## KITTITAS COUNTY COMMUNITY DEVELOPMENT SERVICES

RE: VA-18-00003 Warmenhoven

Mike Flory,  
Building Official

SITE PLAN

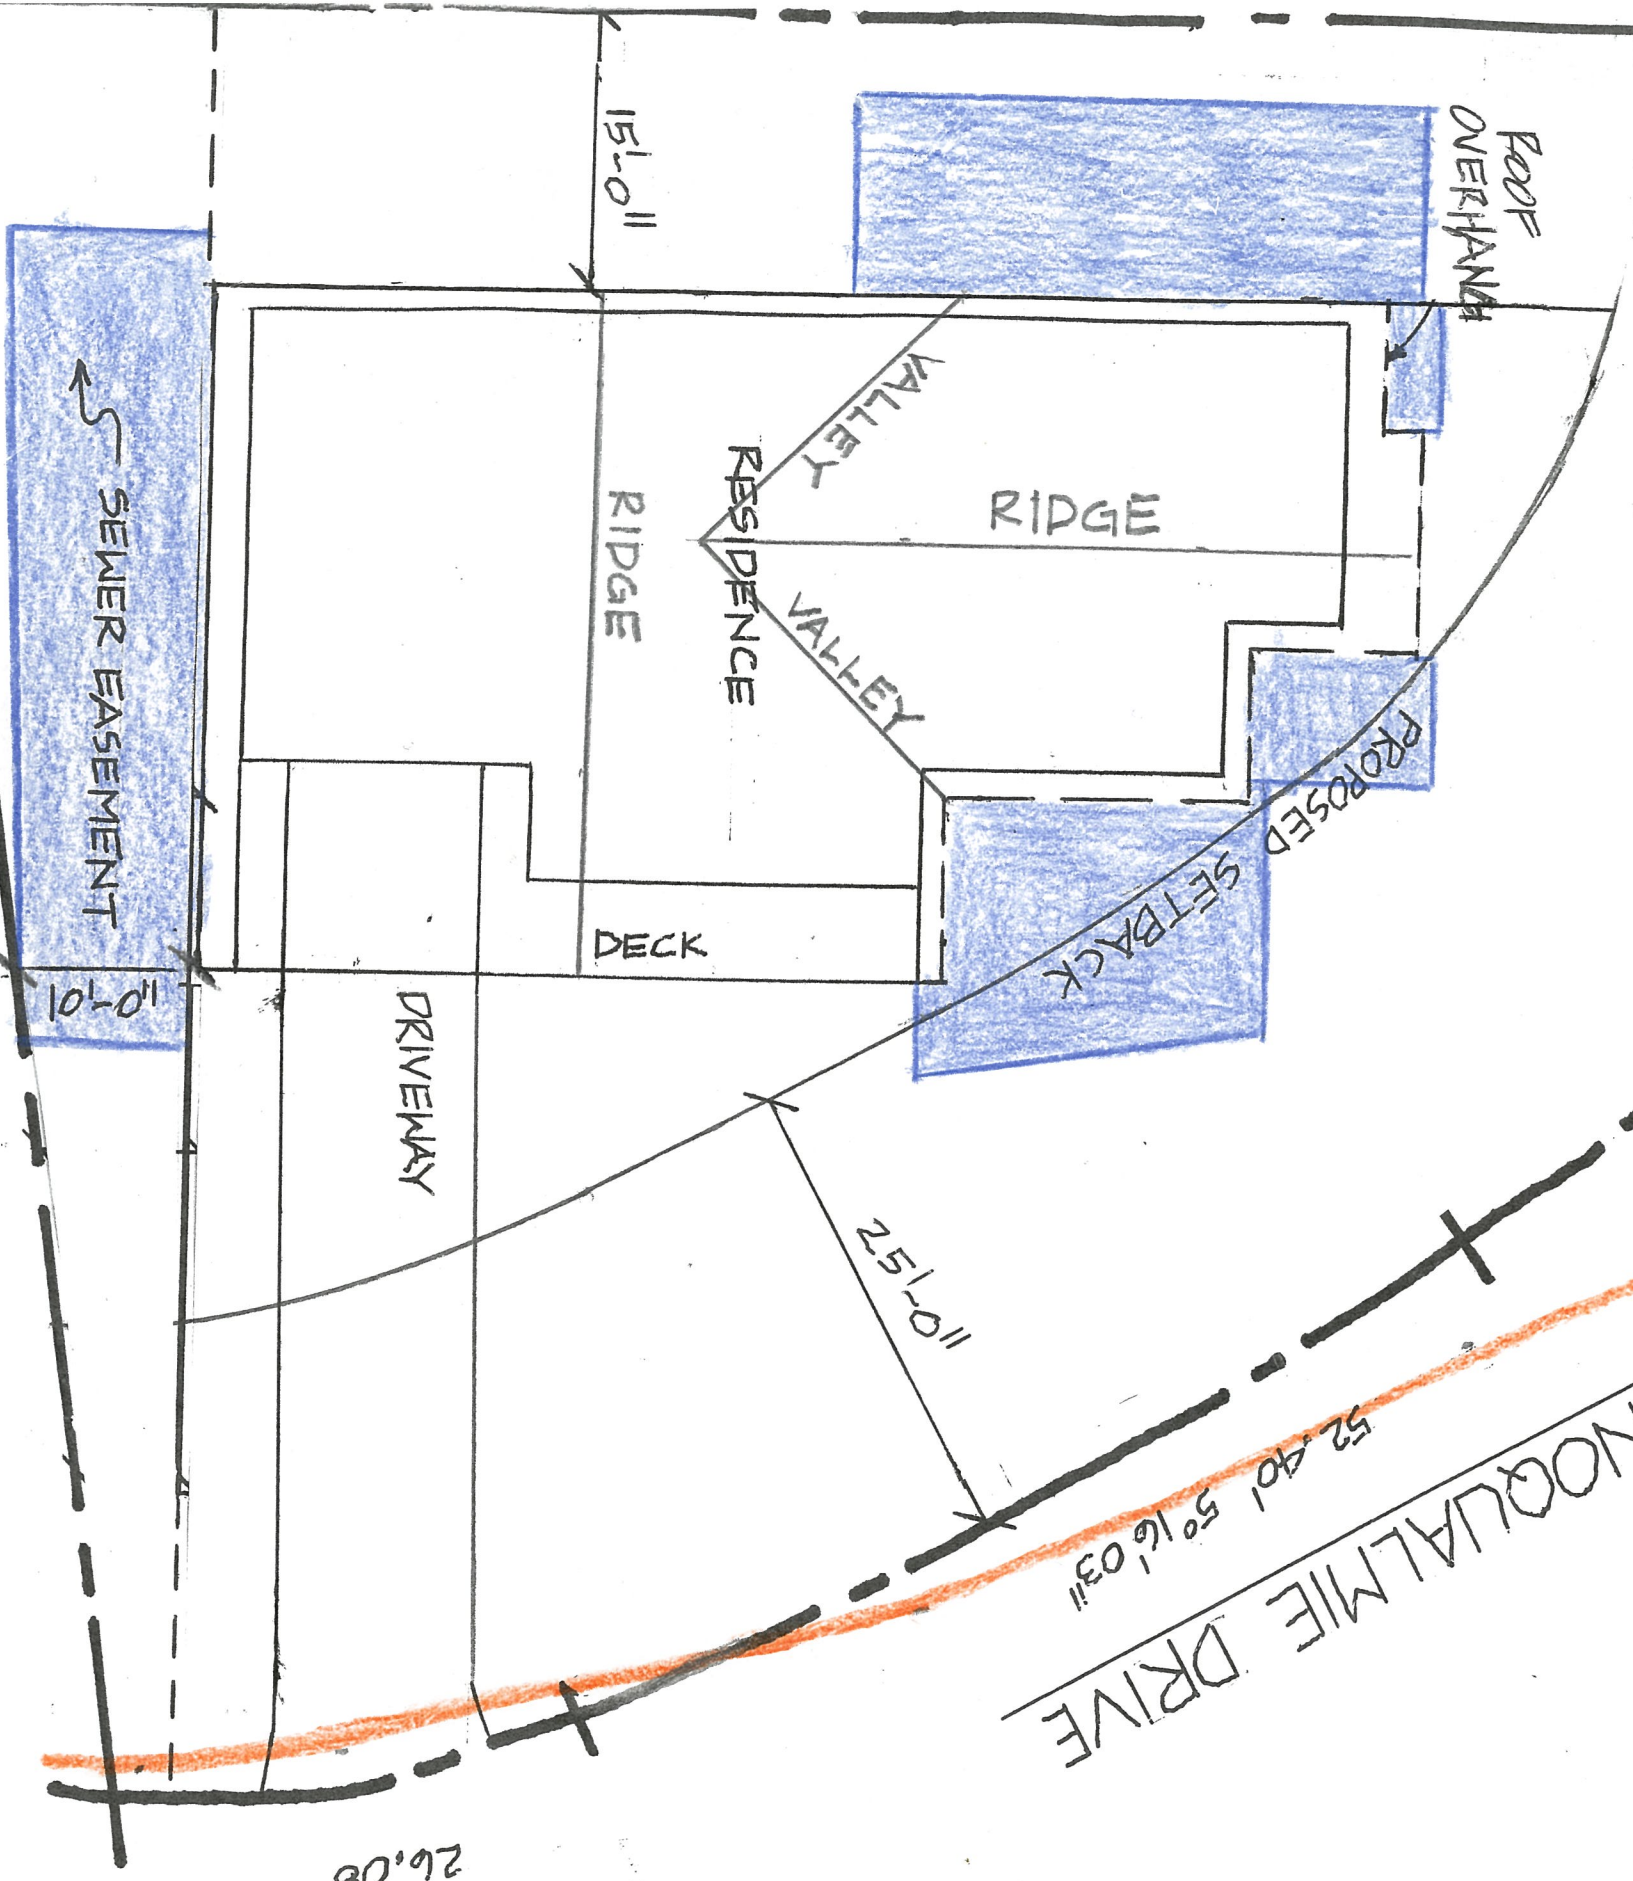
1. The fifteen foot setback requested, when in high snow load areas, can cause structural problems and disputes between neighbors (now and future) when snow continues to slide off a roof and build up on the property line. Building placement and the direction of roof pitch can all change how snow affects the neighboring property. I recommend a snow storage or removal plan be required of the architect or engineer designing the structure and added to the variance if approved.
